Application by Highways England for an Order Granting Development Consent for the M42 J6 Improvement Project.

The Examining Authority's draft Development Consent Order (dDCO) commentary schedule of changes

Issued 8 November 2019

**OPTION 1: INDICATIVE ALT. ARRANGEMENT TO REDUCE IMPACT ON CHURCH FARM LAND**

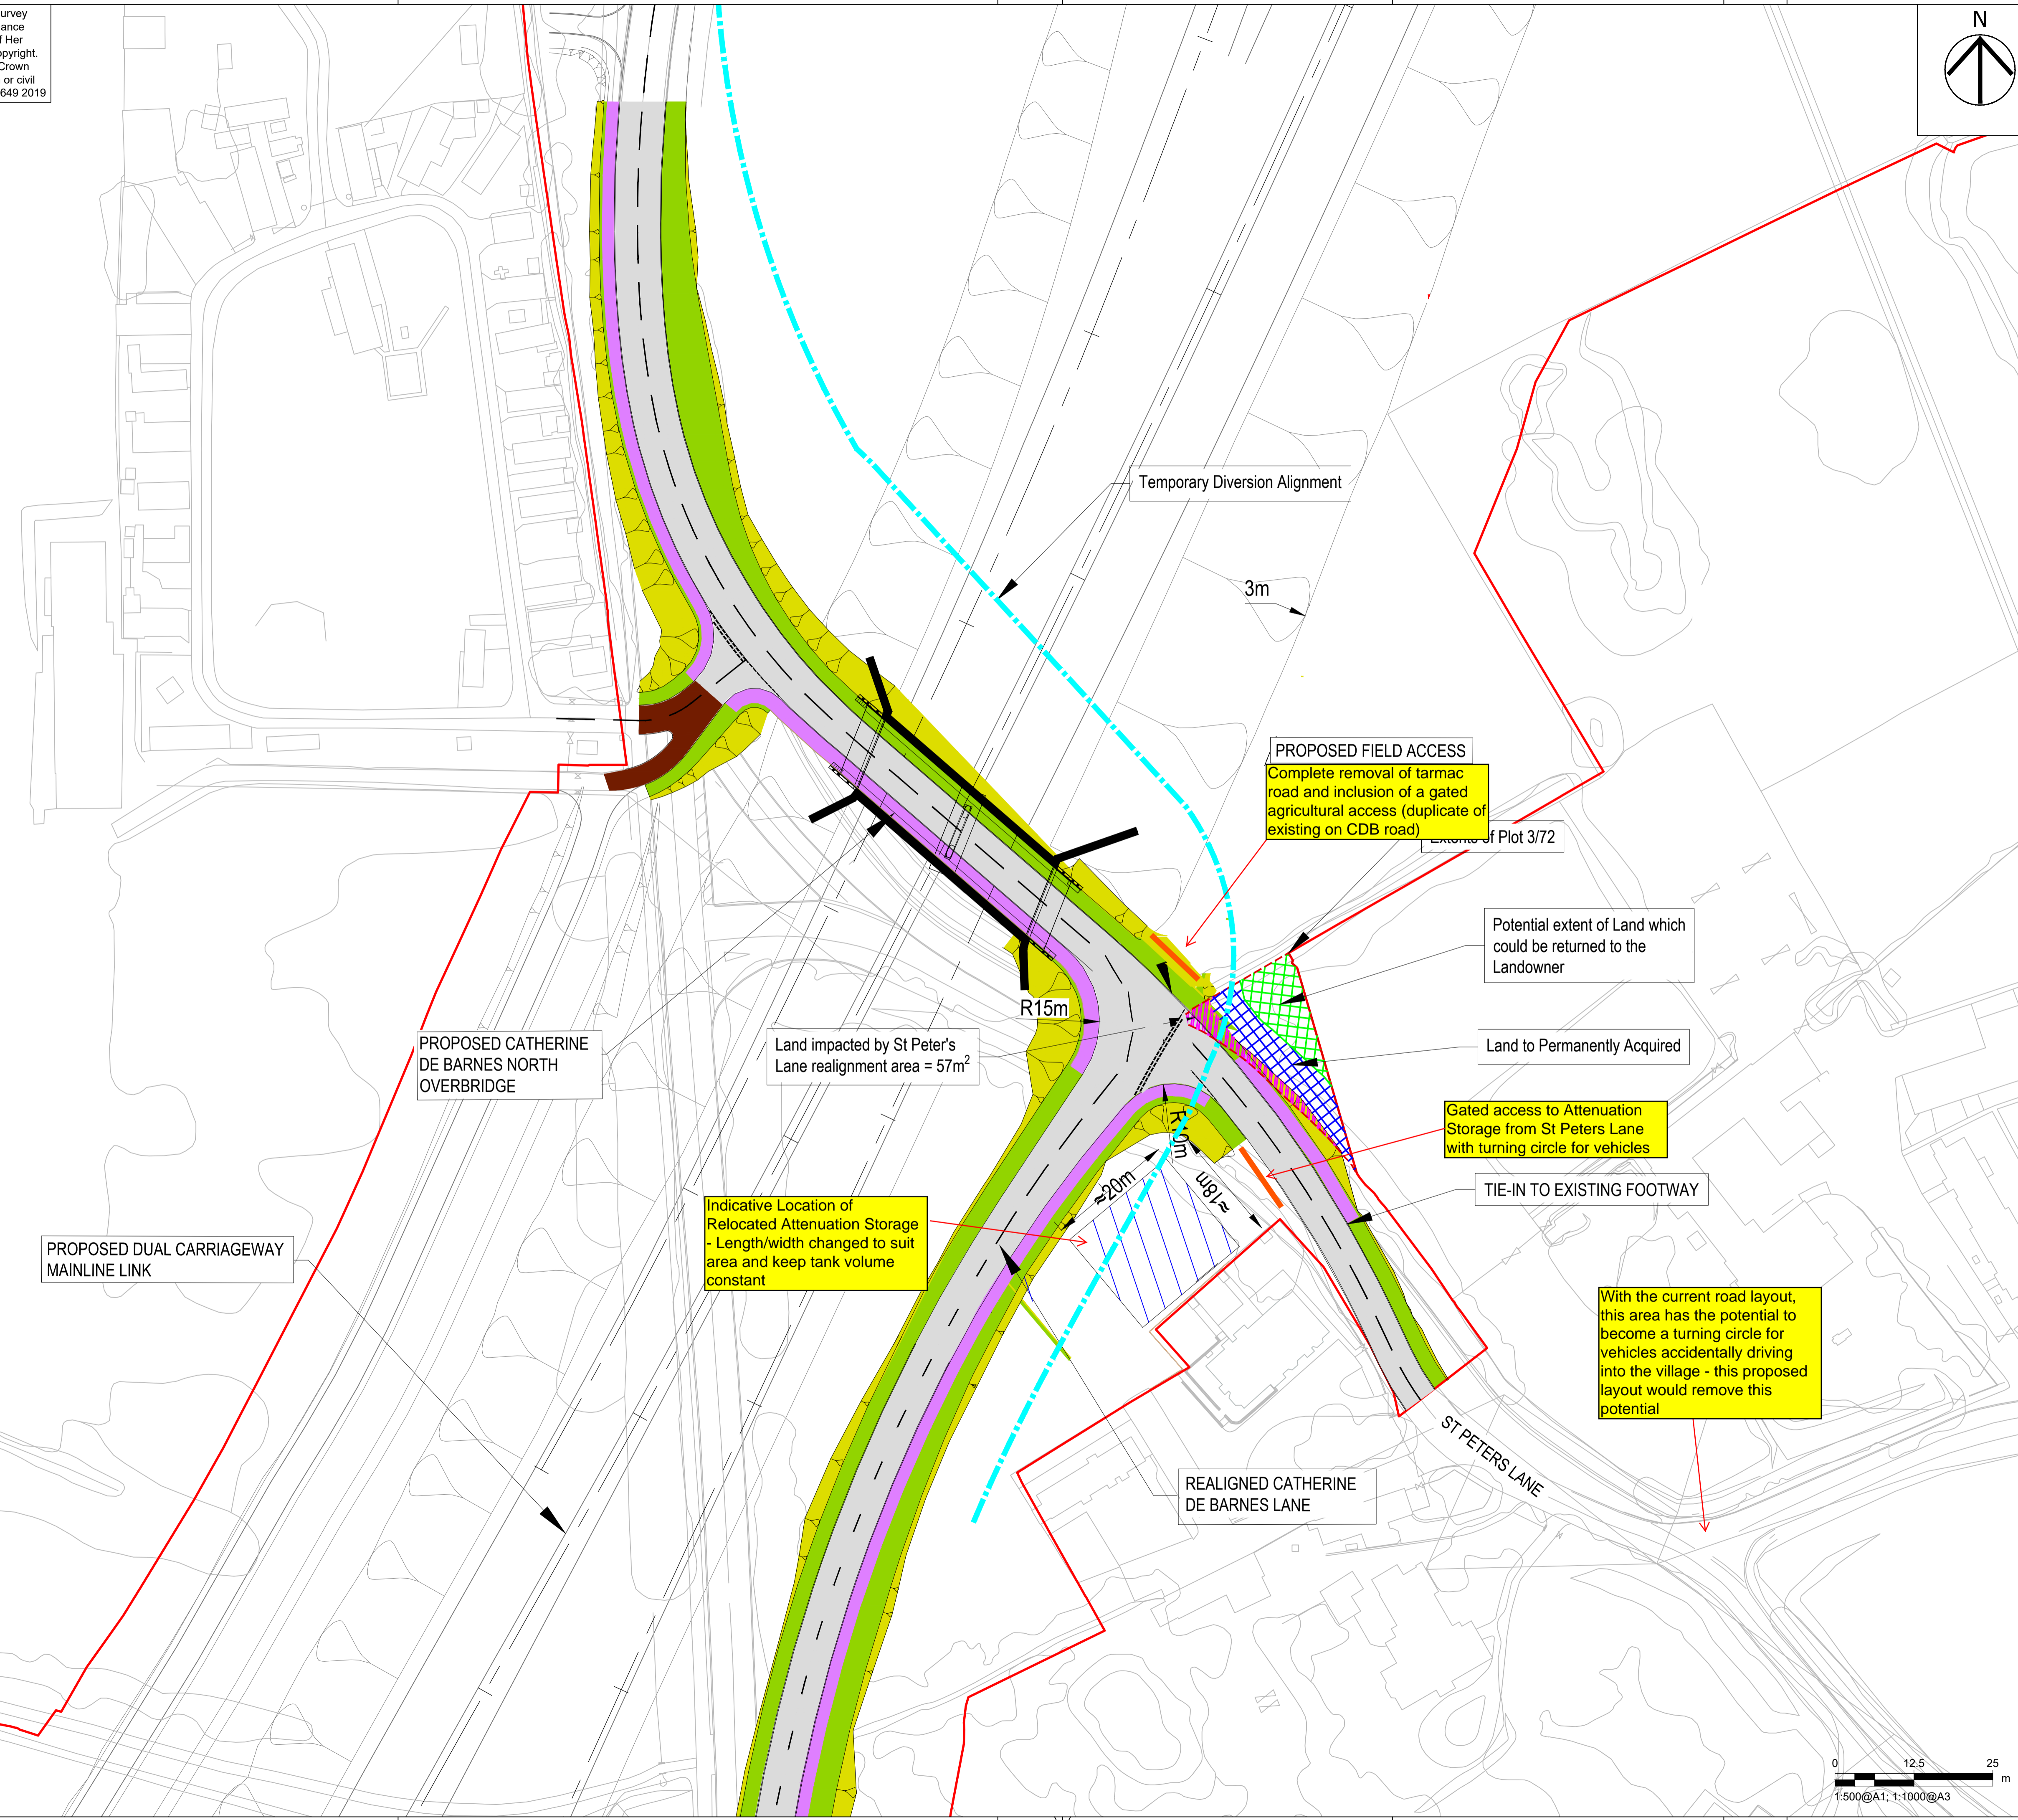
No.	Part of DCO	Relevant extract from DCO (for ease of reference)	Commentary	Response sought from:
13	New R15 Altering the Priority of the Catherine-de- Barnes Lane and St Peters Lane Junction		<p>The ExA note that the Applicant has previously considered the altered priority for this junction but discounted it due to the need for a departure from standards for the horizontal radius of the bend onto the northern overbridge, for the consequent visibility round the bend and for the visibility to the left at St Peter's Lane: and, the possibility that the 'straight' alignment might encourage vehicles leaving St Peter's Lane to do so without stopping. The ExA acknowledge that the road layout might need to be altered, but they do not agree that land beyond the Order limits would be required, or that necessary road signs and safety features would clutter the roadside scene (similar signs and features would be required by the current proposal) or that the departure from standards would lead to worse or unacceptable road hazards; the opposite would be the case.</p> <p>Hence, the ExA propose the insertion of a new R15 as follows:</p> <p>15(1) Notwithstanding the details shown on any Certified Plan listed in Schedule 11 of this Order, no part of the realignment of Catherine-de-Barnes Lane is to commence until a scheme for the northern junction of St Peter's Lane and Catherine-de-Barnes Lane has been submitted to and approved in writing by the Secretary of State, following consultation with the relevant planning authority on matters related to its function.</p> <p>(2) Unless otherwise agreed by the relevant planning authority, the scheme must change the vehicular junction priority from St Peter's Lane to the realigned section of Catherine-de-Barnes Lane.</p>	The Applicant, SMBC, Bickenhill and Marston Green Parish Council, Heath Cotterill, Camila Burton and David Cuthbert
